Response to Planning Application

From: Arun District Council Greenspace

Application ref: A/46/22/RES

Location: Phase 1 - Land off Arundel Road Angmering

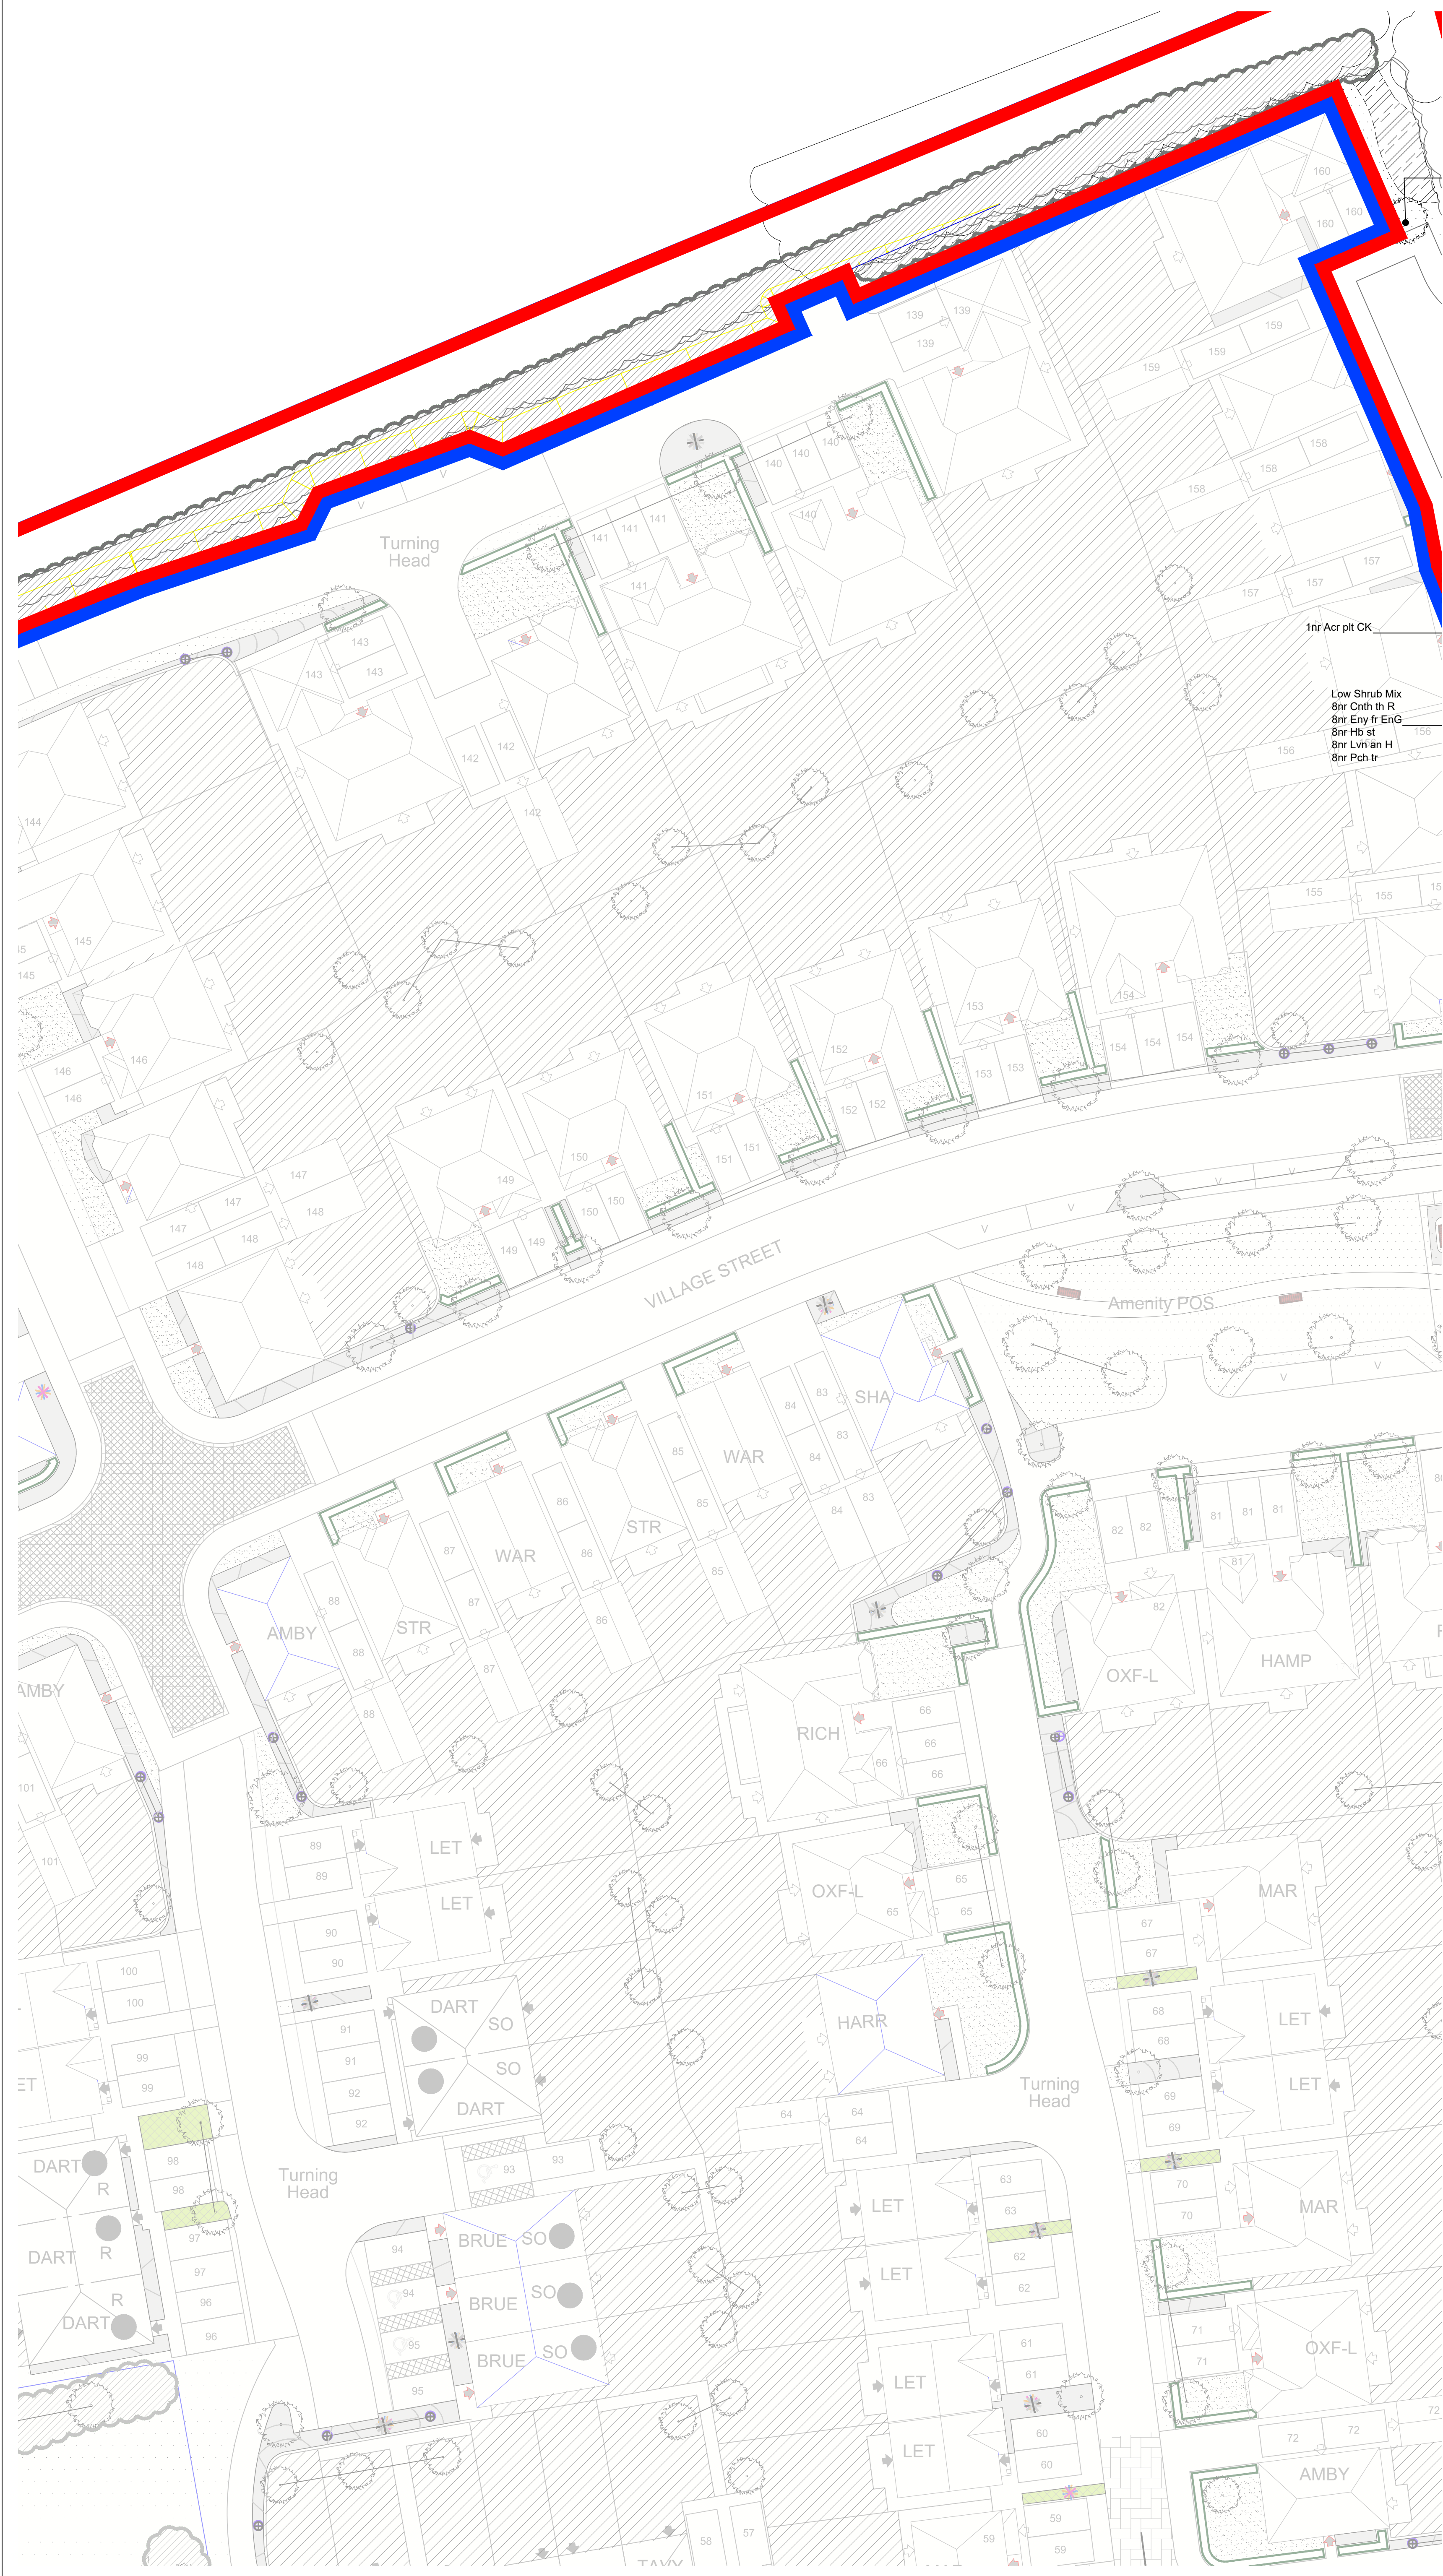
This application has provided landscape detail in the form of a Landscape strategy dwg 120 REV A, Planning and DAS document, Tree and Shrub palette document and detailed Planting Plans 1-4 of 4 Rev's A. Whilst these documents show the picture for this section of the site it does not detail how this will be integrated within the wider site context which is information that should be a consideration.

A full landscape scheme for this red line portion of the site has been submitted; detailing species choice, position, densities and size at time of planting. This has been plotted in plan and list form and in relation to the trees and vegetation to be retained, however the wider context landscaping is yet to be submitted and therefore full backing of the proposals could not be made until the wider context and integration of both has been made.

Recommend that the landscape context of the wider site is considered including all areas of POS and buffer planting. Recommend that the outline application is considered re the entrance POS to ensure that the site is not compromised by the depletion of the green buffer in this location.
